Subject OBJECTION TO PLANNING APPLICATION

Planning Application No: 3/2022/0265
Grid Ref 363549 441223

Proposal: Proposed erection of a farm workers dwelling and the creation of a new access off the public highway.

Location Thornley Hall Farm Up Bedlam Road Thornley PR3 2TN

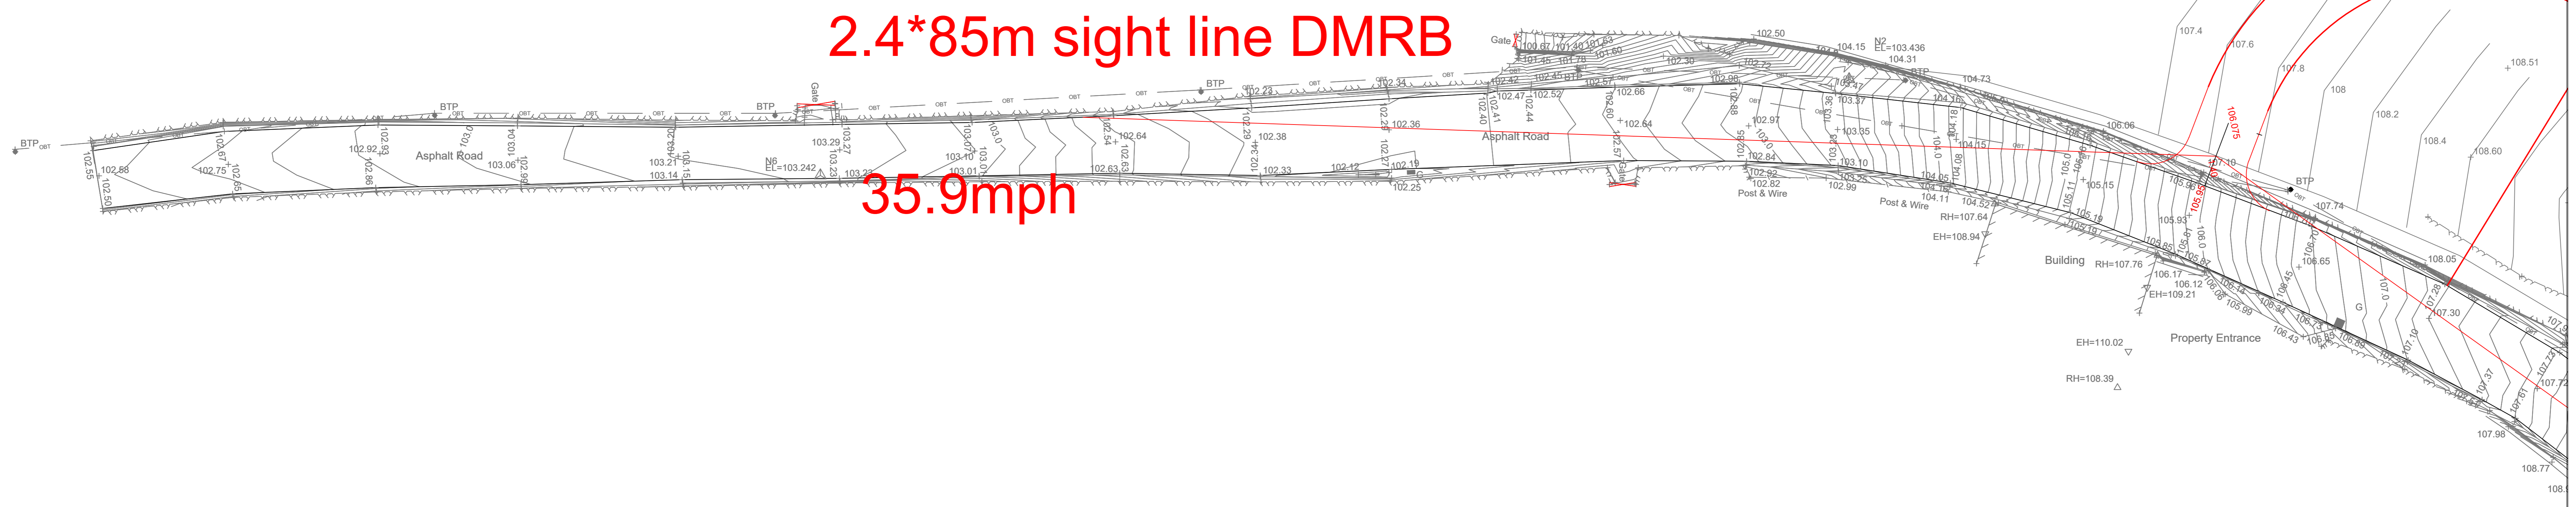
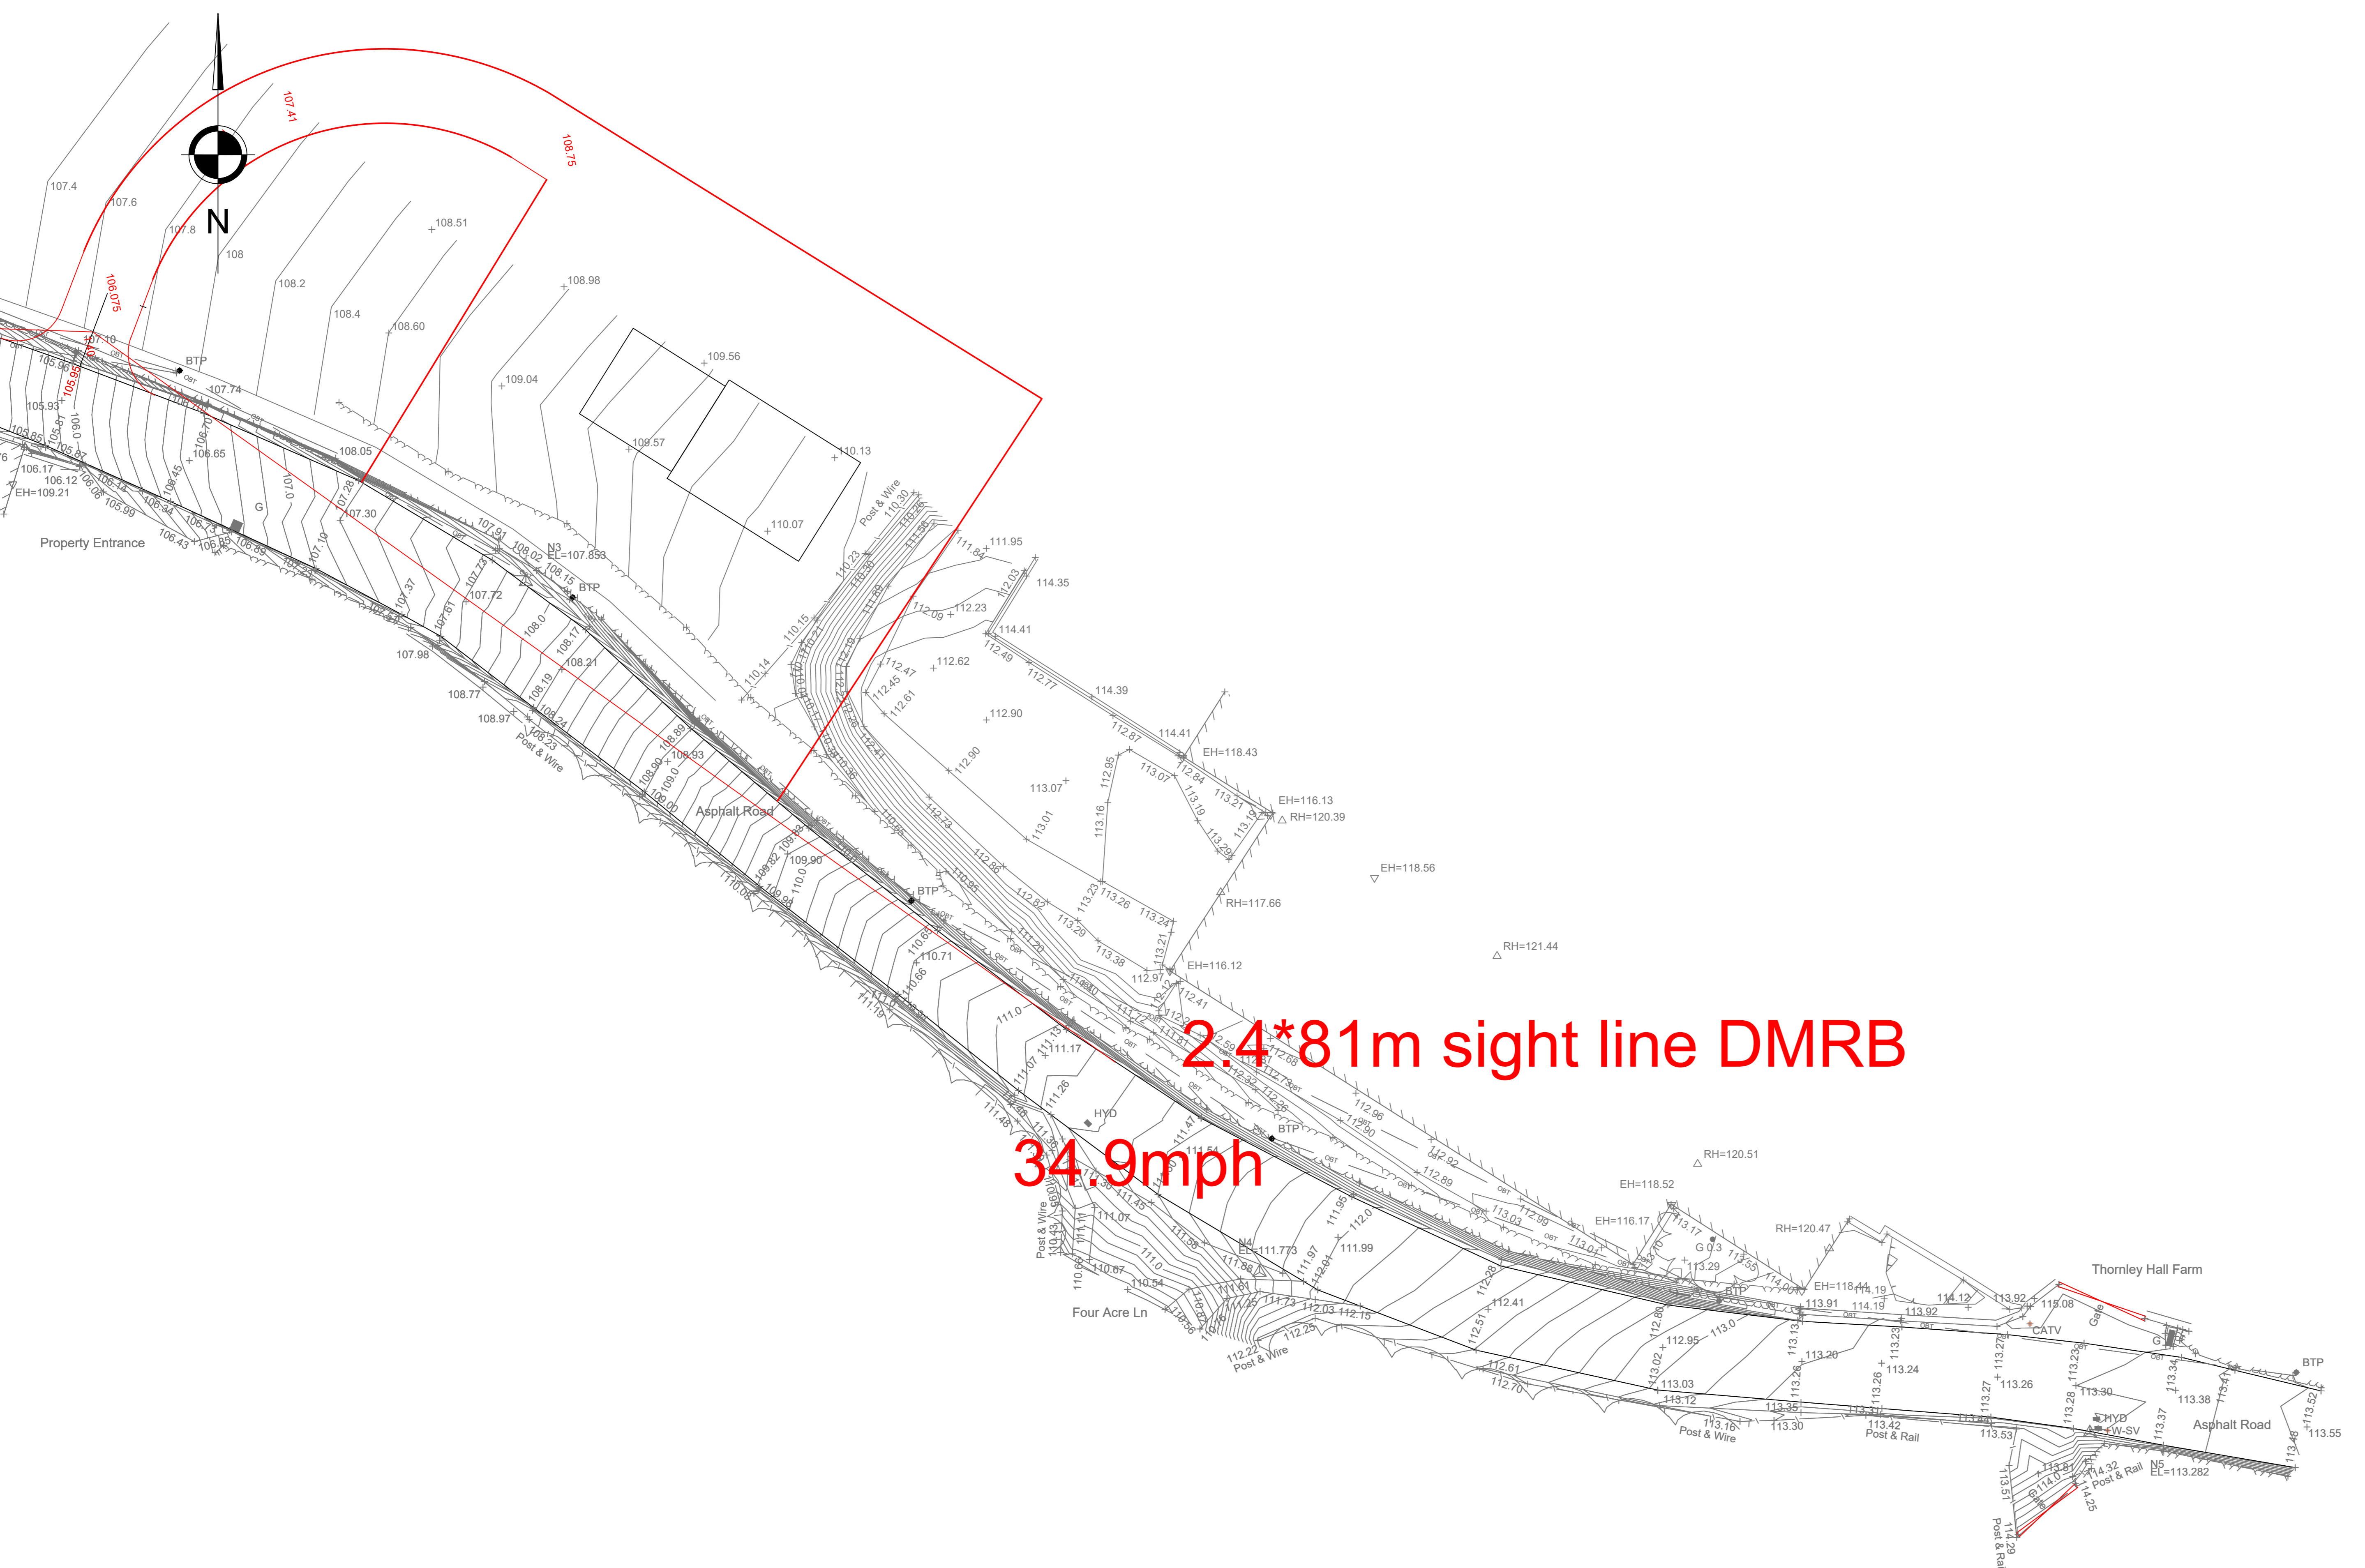
Why is a new access off the public highway required.?

I believe creating a new access entrance in close proximity to [REDACTED] will increase the hazards that [REDACTED]

Skid marks on the road surface in this area (a common occurrence) is a constant remainder of the dangerous road conditions and near misses. The proposed new access is also in a (sun blind spot) as the sun rises in the morning it blinds approaching motorists.

Farm vehicles already have access to the proposed dwelling site via the farmyard. Just like the access to the existing dwelling accommodation on the farm site. The existing farm entrance is an established and well known entry.

More building Work, more concrete, in the near vicinity to my property with result in less penetration of rain water in to the nearby land. Thus creating more surface water run off, on to the highway. The proposed new access road would funnel a vast amount of extra surface water out on to the highway. Evidence of water damage to the road surface is clearly visible.
